Monday, 14 November, 2016

CROOKWELL III WIND FARM: PUBLIC SUBMISSION

Proximity of Wind Turbines to “Highland Park” homestead.

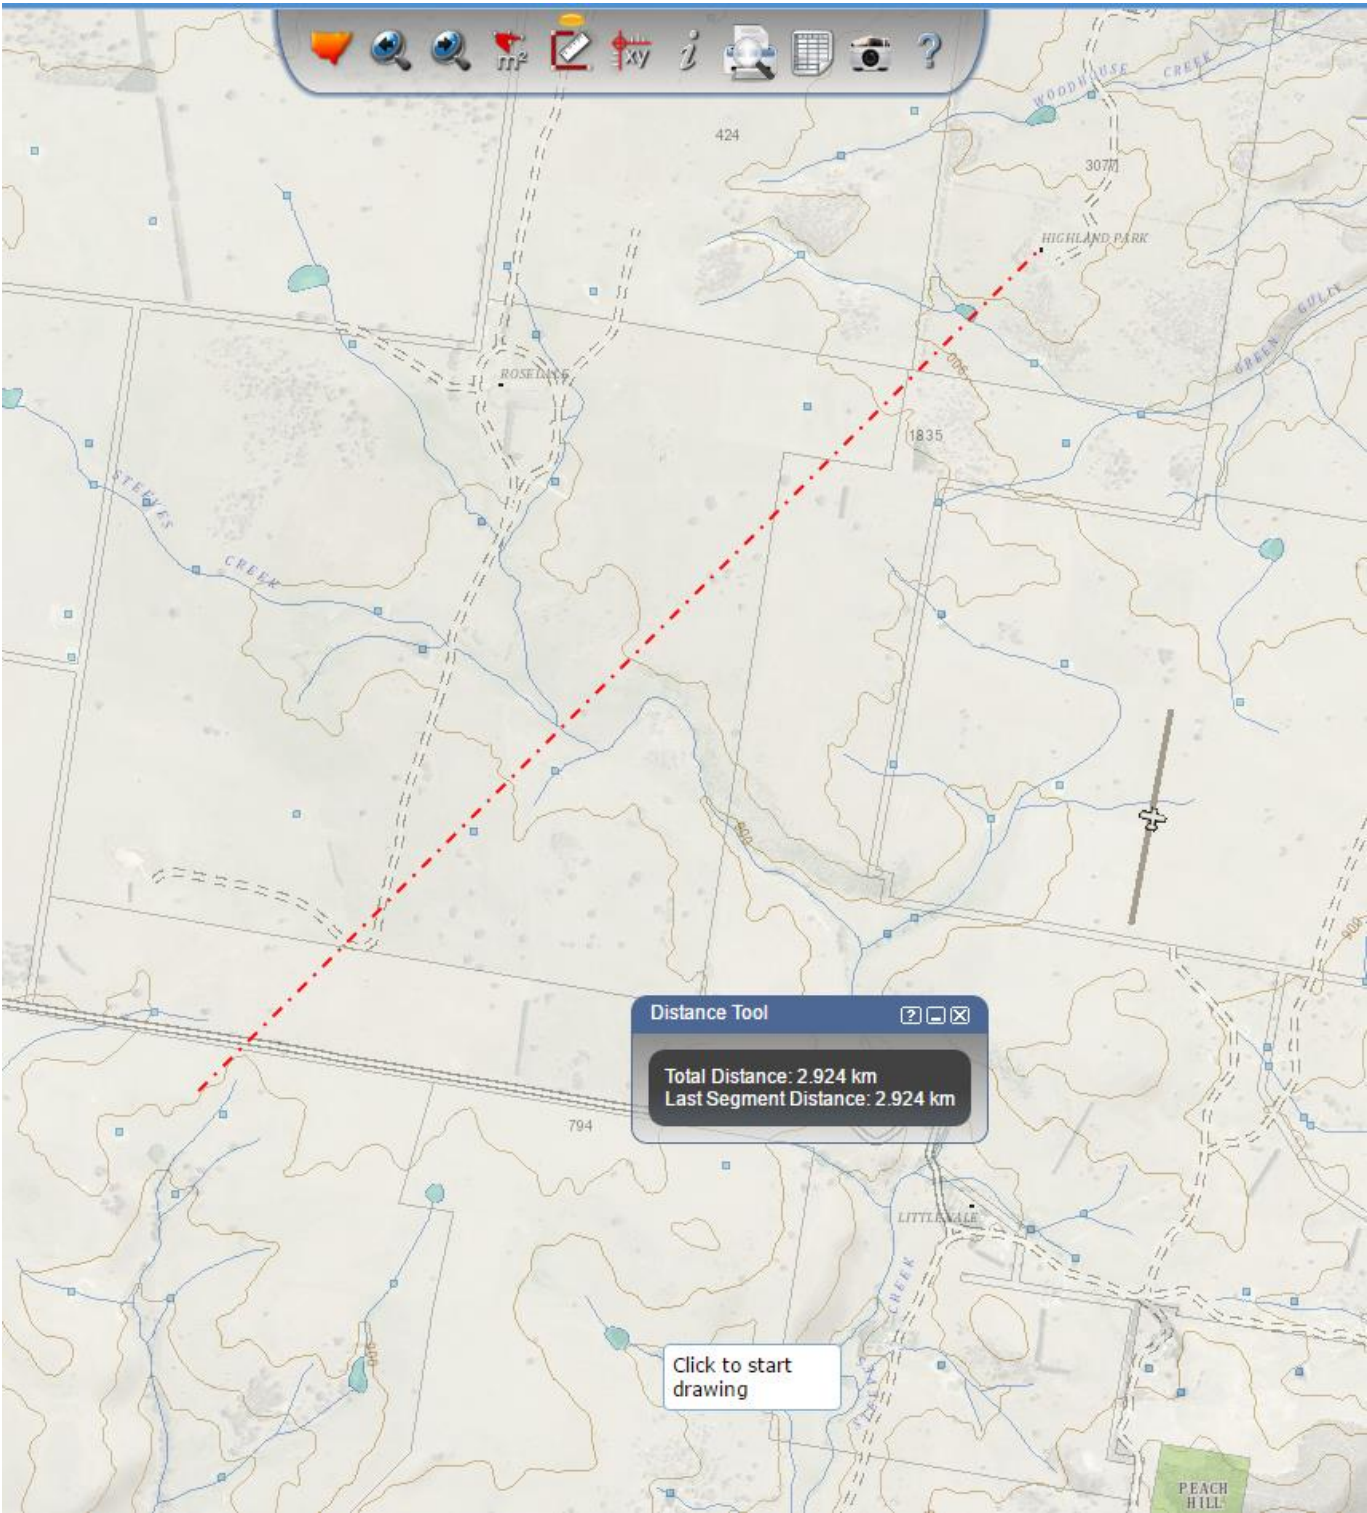
1. It shows incorrect distances to the closest turbine (2.7km vs actual at 2.6km)
2. It assesses the scenic quality in lesser terms to that which is accurate and described in the foreword of the report and
3. Assesses the visual impact of the towers and blades as negligible which is manifestly false.
4. Under the guidelines for visual assessment as noted in the attached; the closest turbine should be a minimum of 3.2km from the residence numbered in the visual assessment as 104 "Highland Park".

Currently there are up to 5 turbines proposed within said 3.2km zone. (refer appendix 2b)

Given the house 104 (Highland Park Homestead) is at a similar RL to the closest and incorrectly sited turbines A3, A4, A5 & A9 – Will the department stipulate a review of house 104 and other affected residences?
